**CITY OF PORTLAND**  
**Planning and Urban Development Department**

**MEMORANDUM**

**SUBJECT:** Request for Certificate of Occupancy  
Lot 13, Turnpike Industrial Park  
Riverside Street

On June 25, 1998 the site was reviewed for compliance with the conditions of approval dated 2-24-98; my comments are:

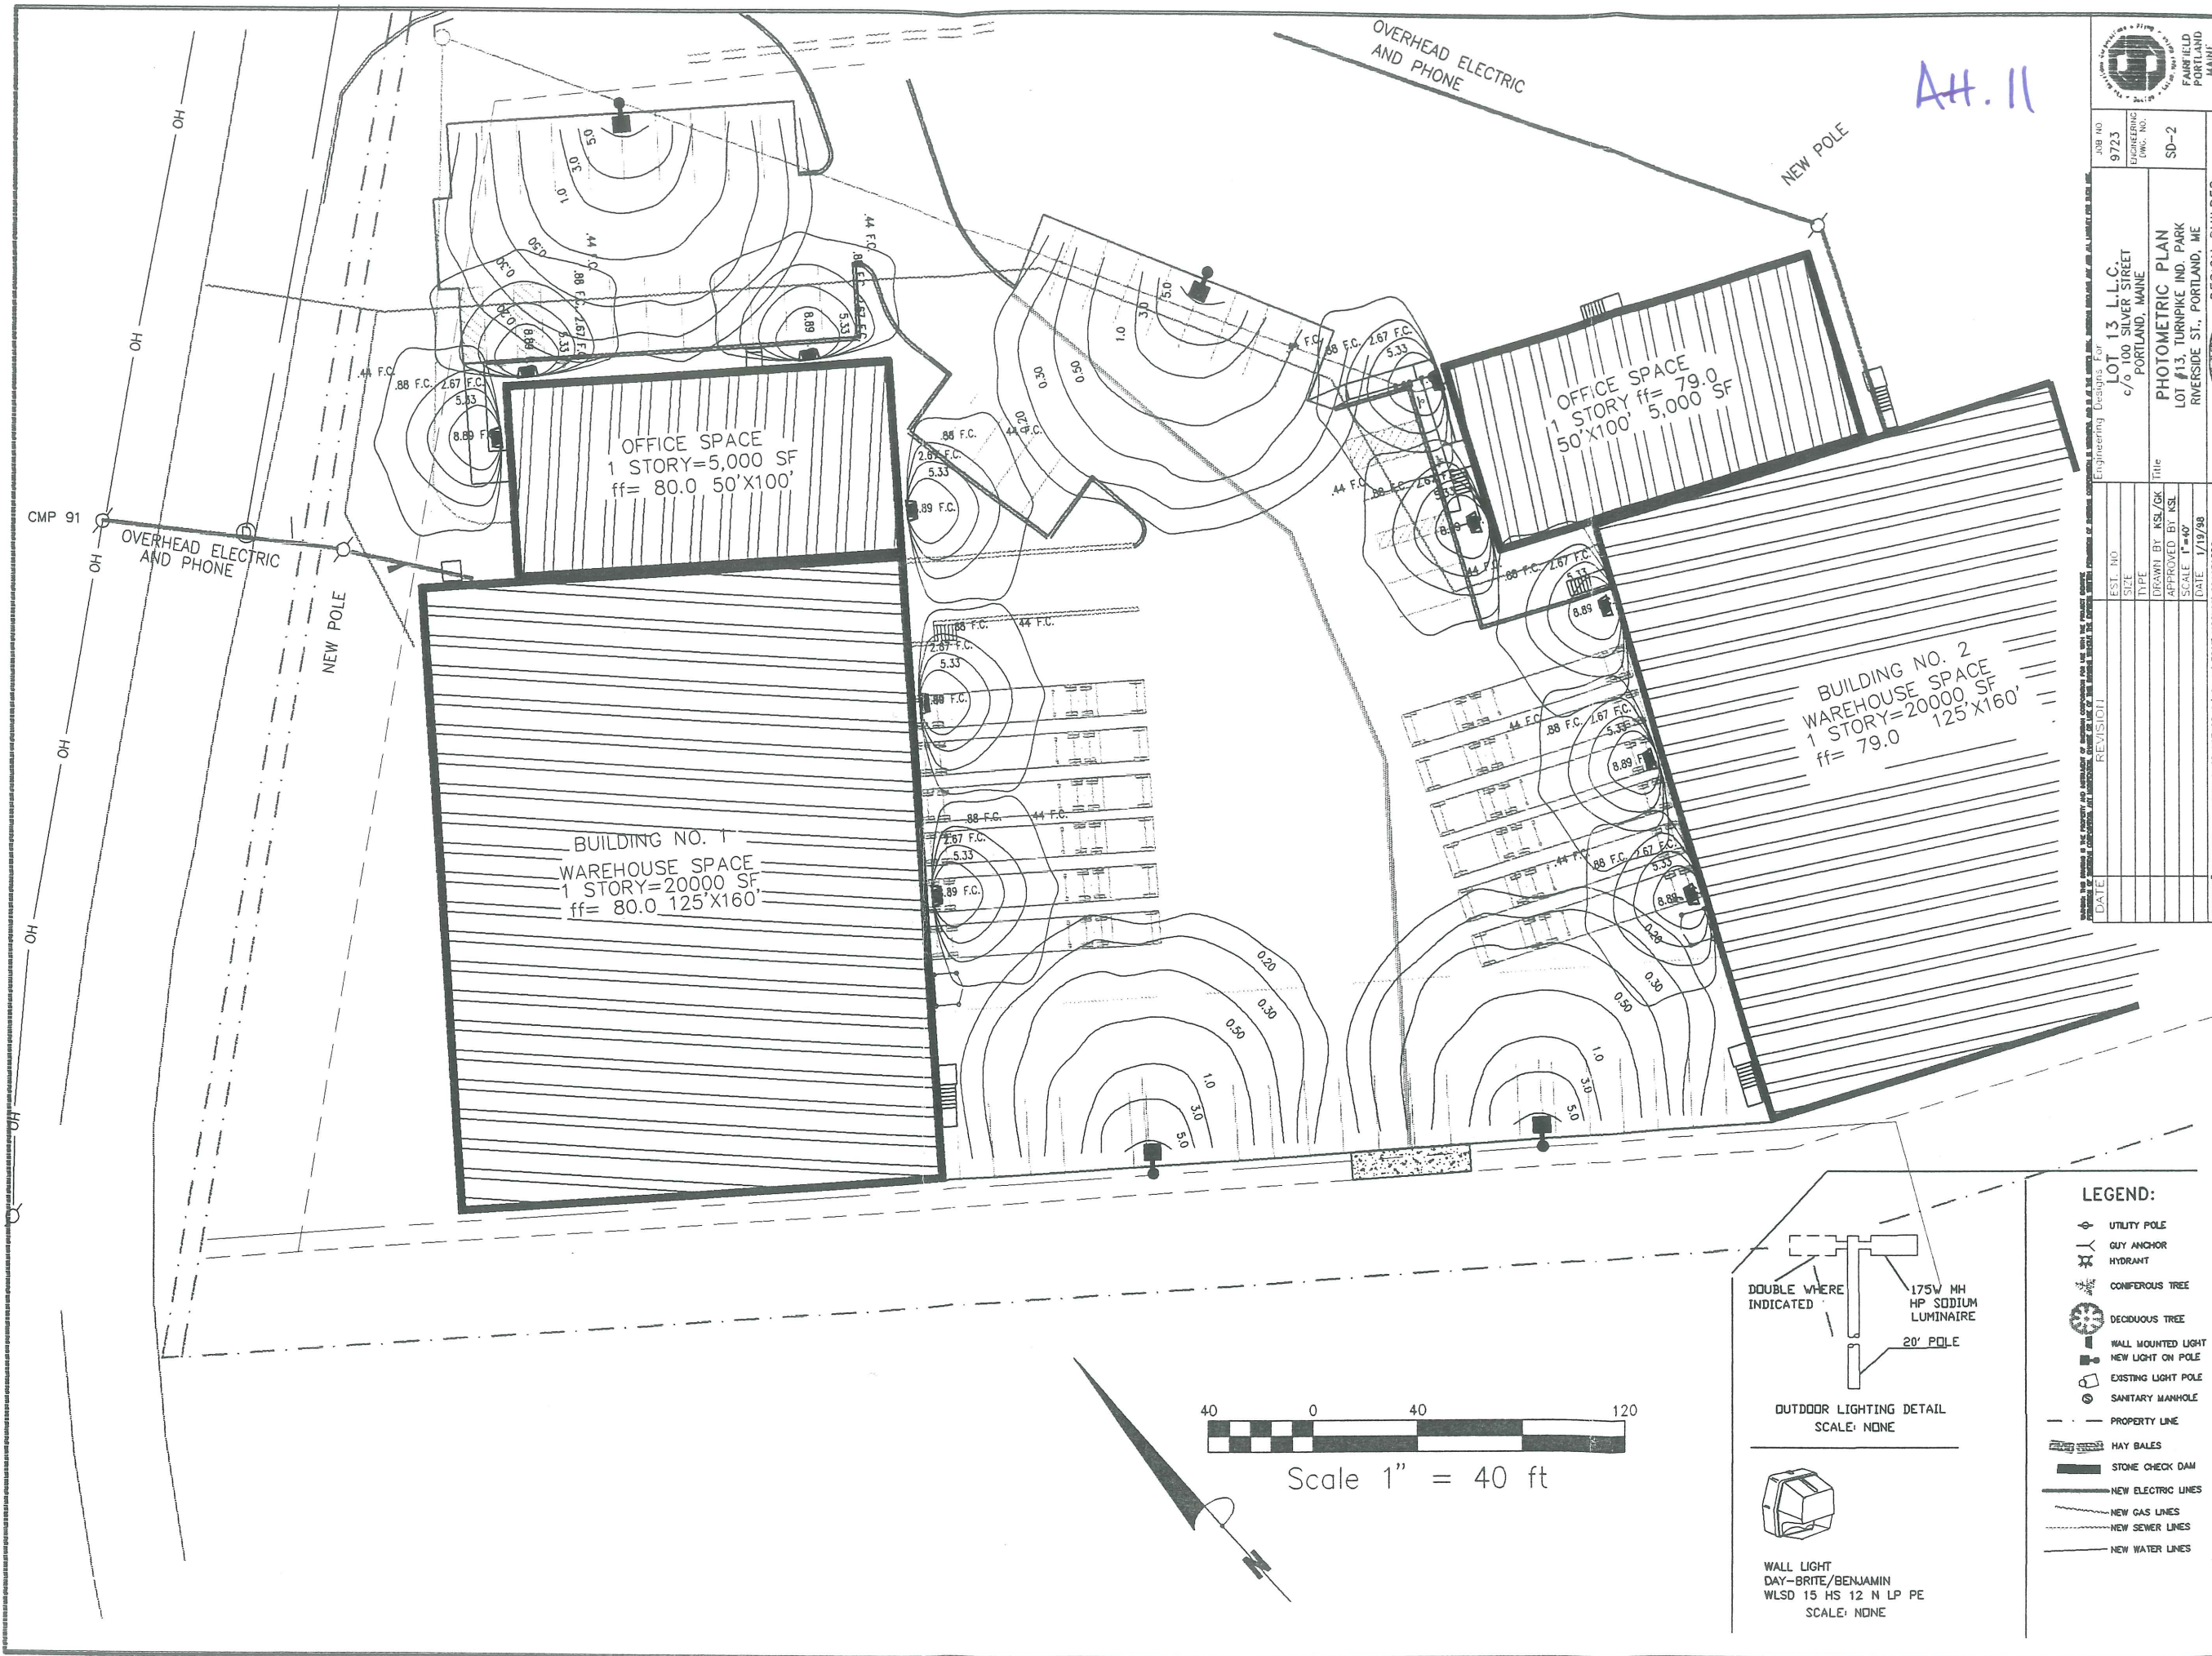
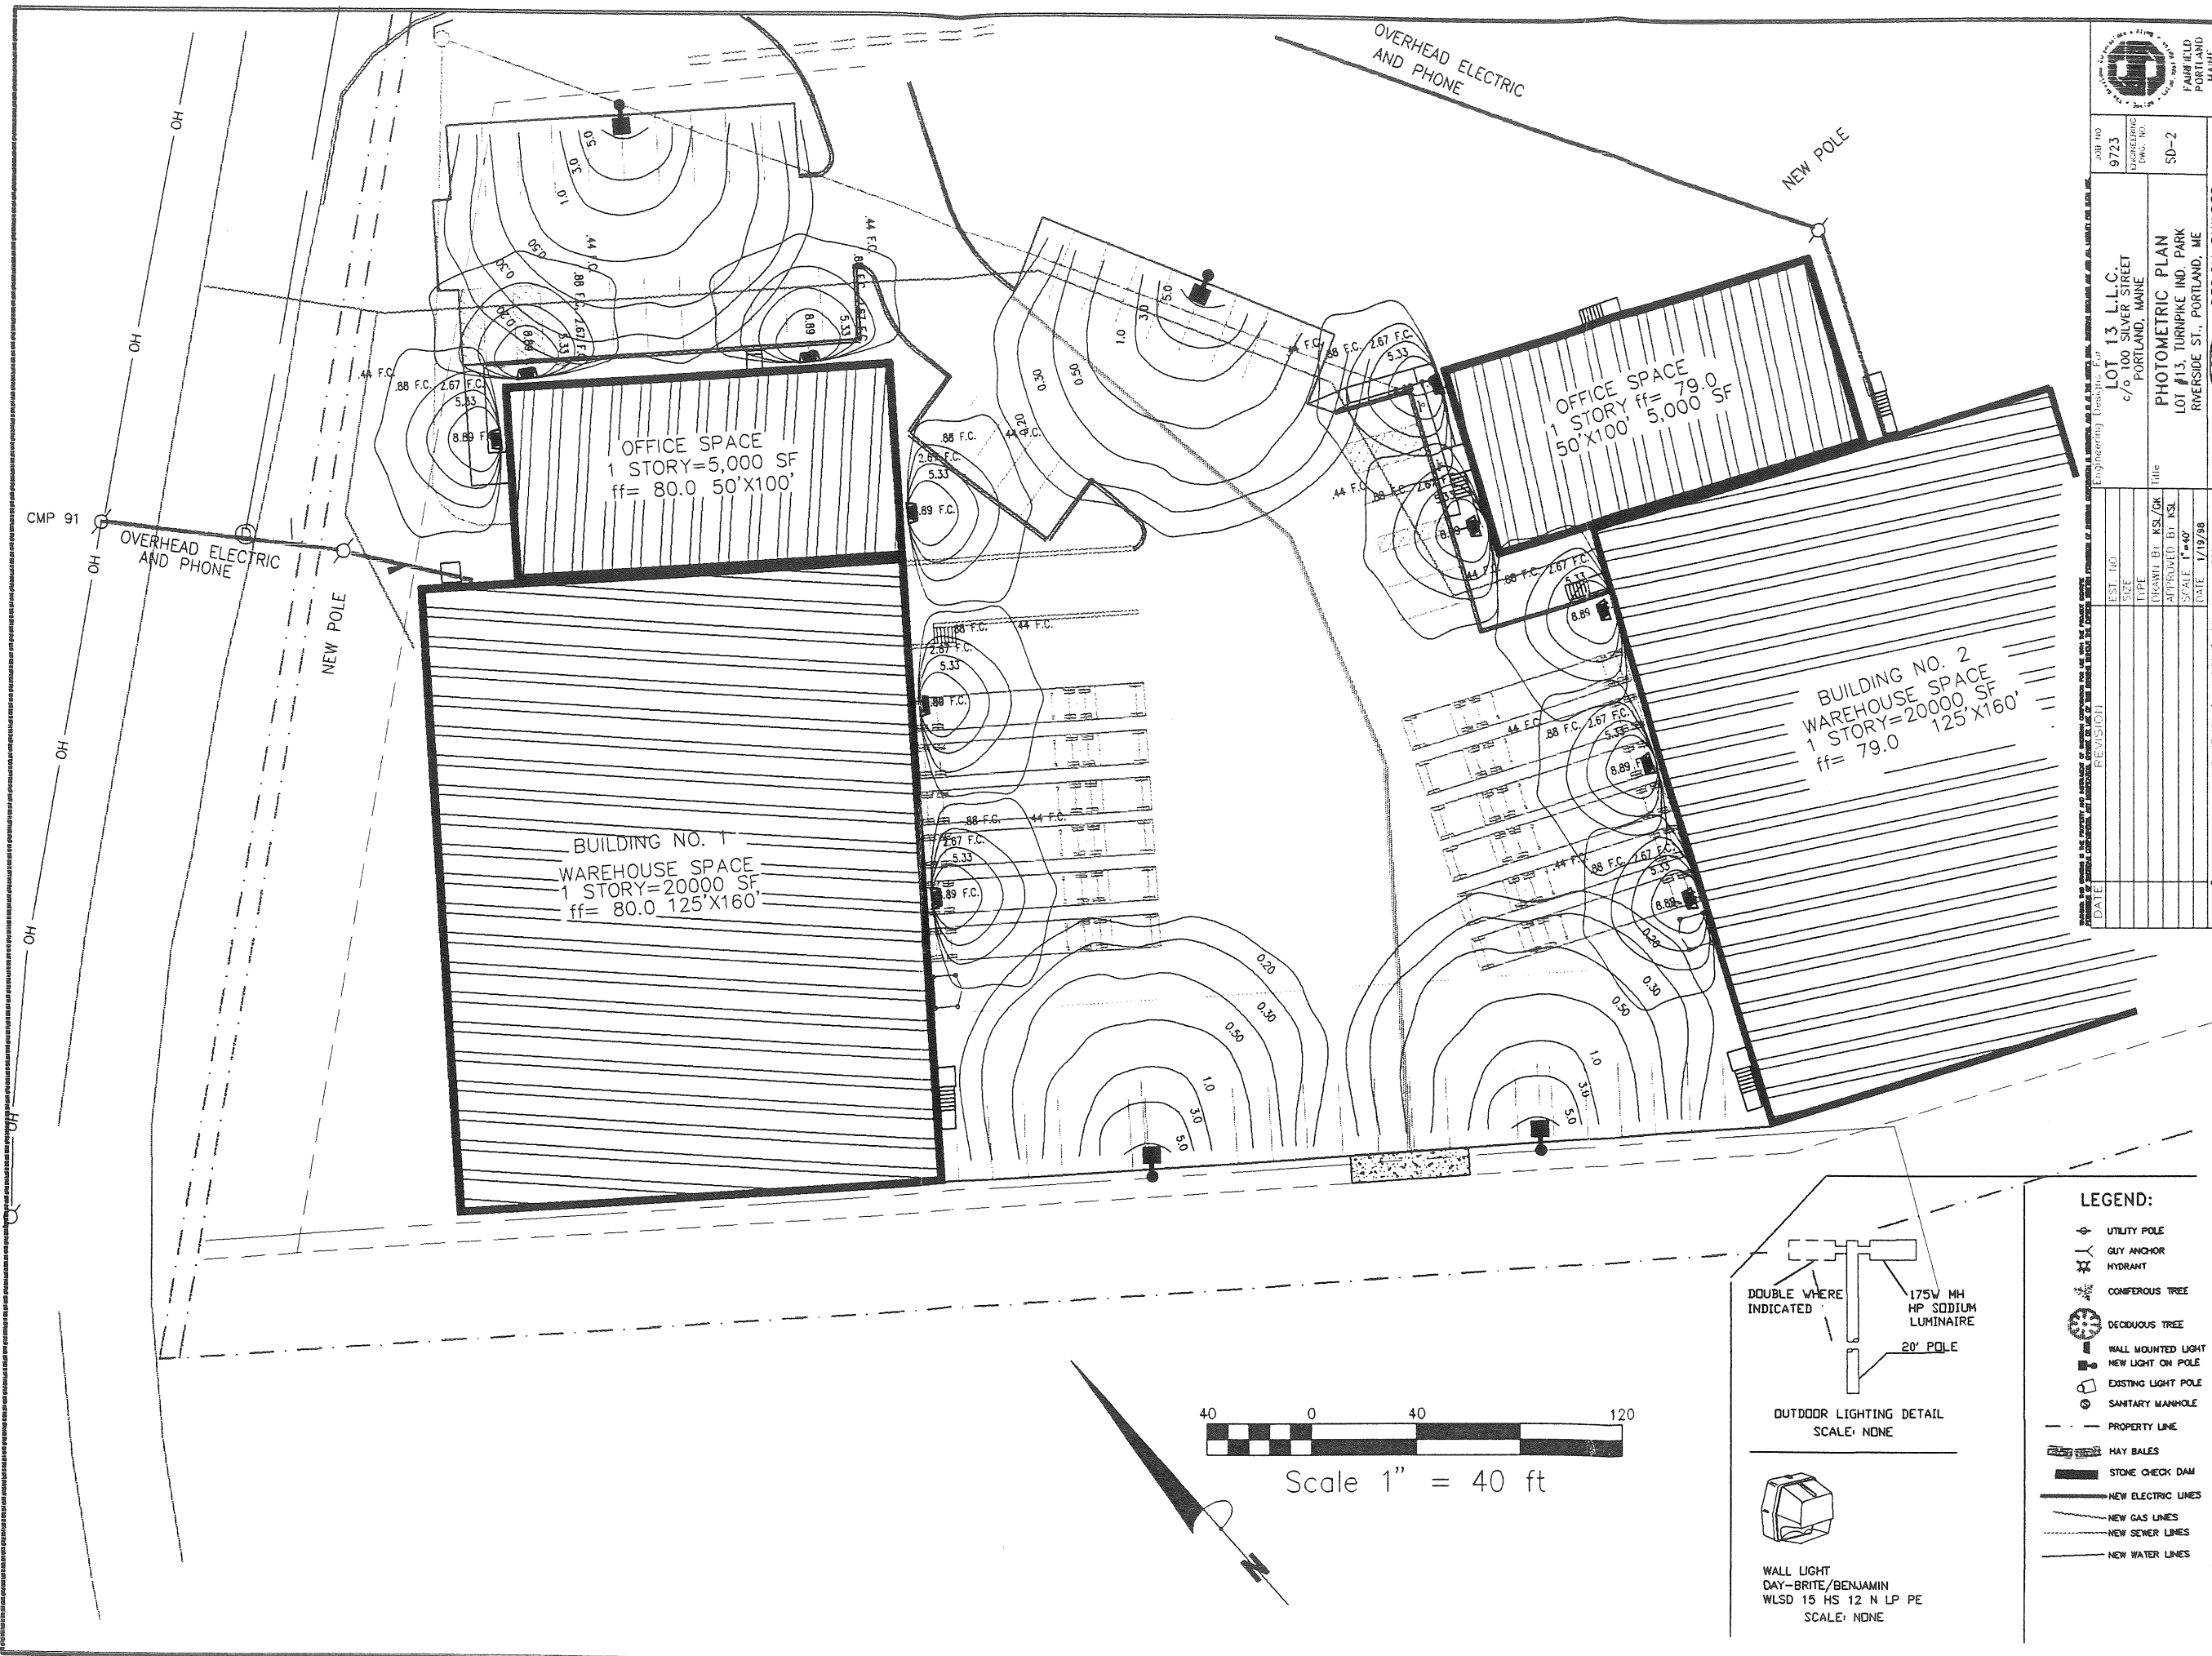
1. The bituminous curb must be extended to the granite curb at the shared entrance onto Riverside Street. To accomplish this requirement two existing lengths of granite curb must be removed and additional gravel and pavement is required to widen the entrance sufficiently to allow the placement of the bituminous curb. The slope behind the curb must be graded to the top of the curb, loamed and seeded. This work must be completed by July 31, 1998.

2. The site requires extensive erosion control maintenance. This work must be completed by July 10, 1998.
  - a. Eroded gullies must be filled, loamed and seeded.

- b. Eroded soil must be removed from swales and riprap aprons.
  - c. Bare areas must be reseeded as necessary.
3. Erosion control blanket must be installed in the swales per the approved site plan. This work must be completed by July 10, 1998.

4. Disturbed and unvegetated area around the utility pole near the site entrance must be graded and stabilized. This work must be completed by July 10, 1998.

5. Since only one building was constructed, a revised site plan showing the extent of this construction must be submitted to the Planning Department.
